Demolition of 1 No. existing house & grounds & erection of 2 No. new detached dwellings. This application may affect the character & appearance of the Station Road, East Preston Conservation Area.

St Marys Close Hurst Road Rustington

Thank you for your internet representation made on 28th September 2018 which has been recorded as '**an objection**' with the comments as follows:

Drawing Title:
ADDITIONAL DWELLING
PLOTS 1 & 2
ELEVATIONS

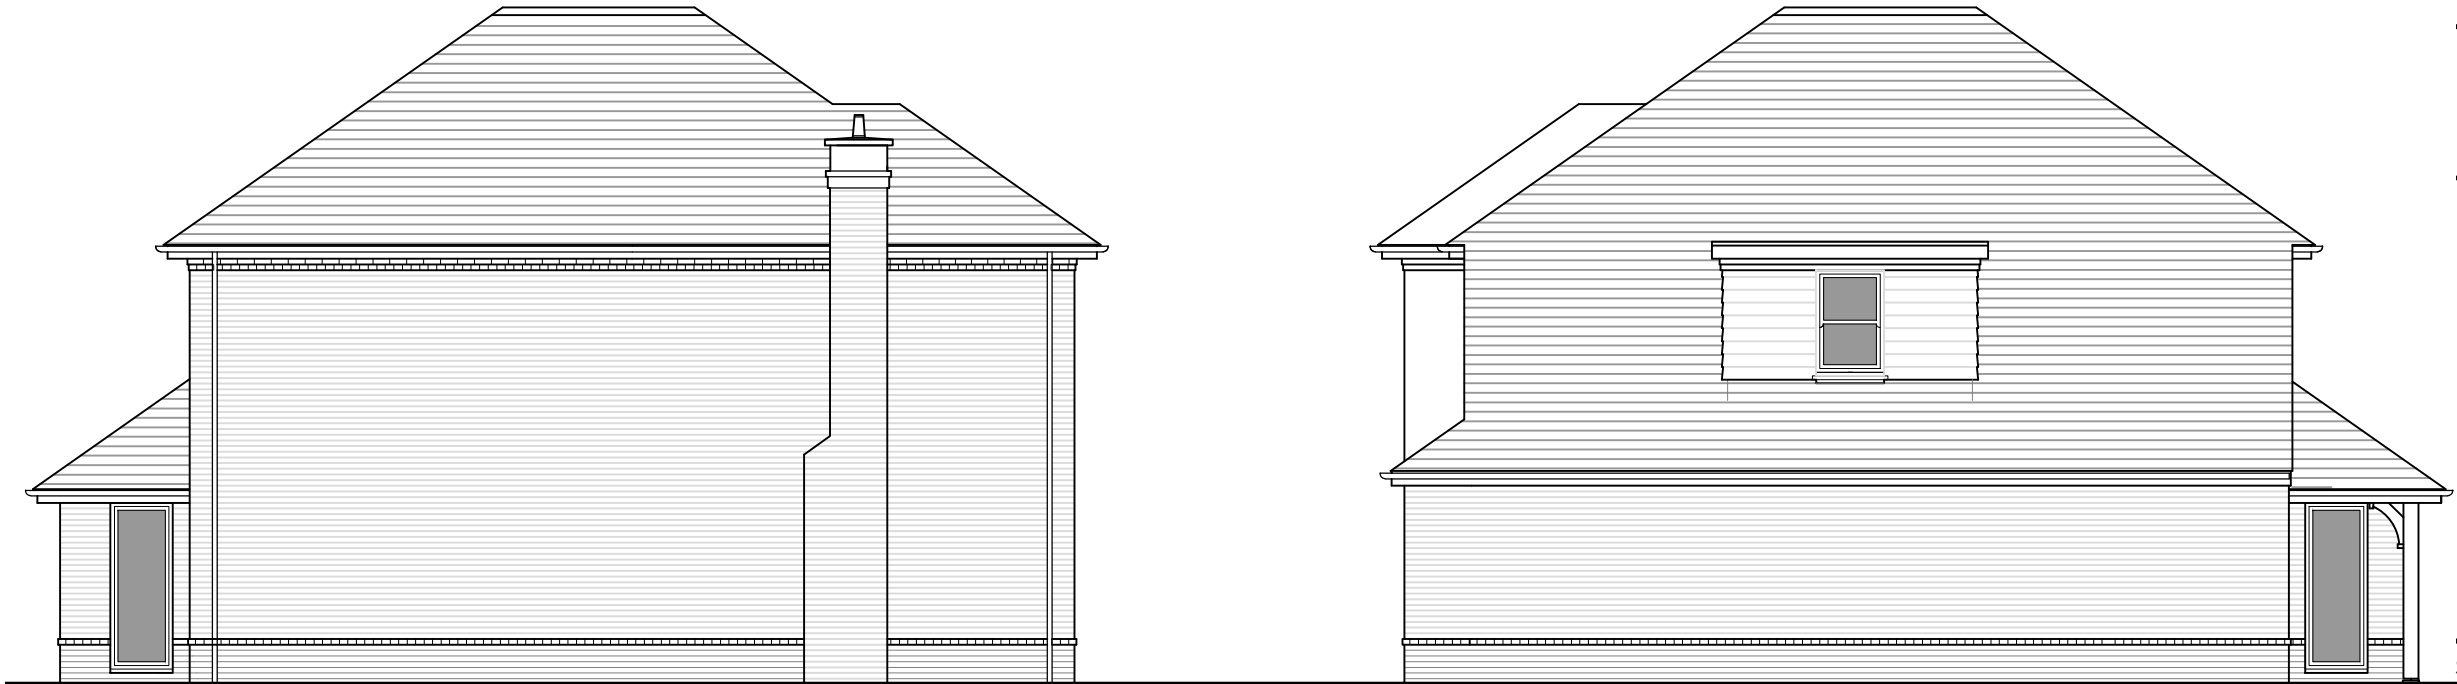
The developer (MJH) is proposing building two identical houses. I am objecting to identical houses as the development would be harmful to the character and appearance of Hurst Road as Hurst Road is characterised by a mixture of houses and bungalows/chalet bungalows of varied designs that occupy quite spacious plots.
